CITY OF ALBUQUERQUE

December 9, 2019

Re: Project Name
3301 Candelaria Road NE
Traffic Circulation Layout
Engineer's/Architect's Stamp 08-21-2019 (G16D097)

1 Site Plan - Proposed
Scale: 1" = 20'-0"

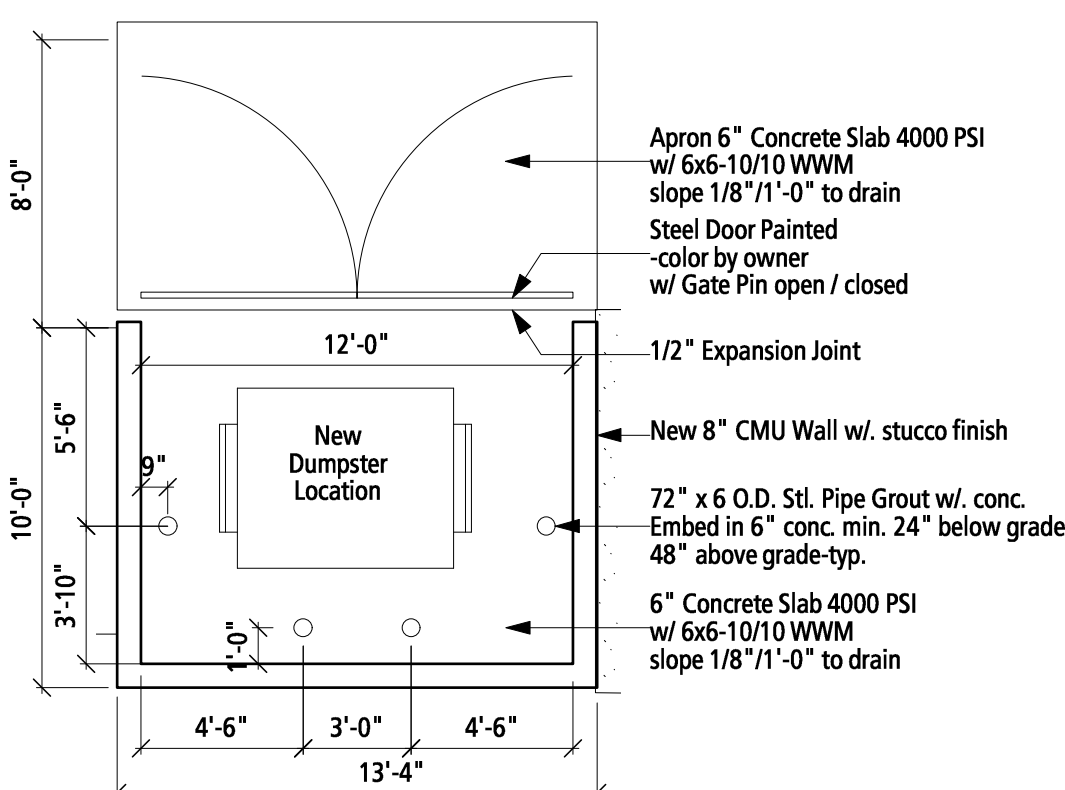
1. Per DPM, a 6 ft. wide ADA accessible pedestrian pathway is required from the ADA parking stall access aisles to the building entrances. Please clearly show this pathway and provide details.
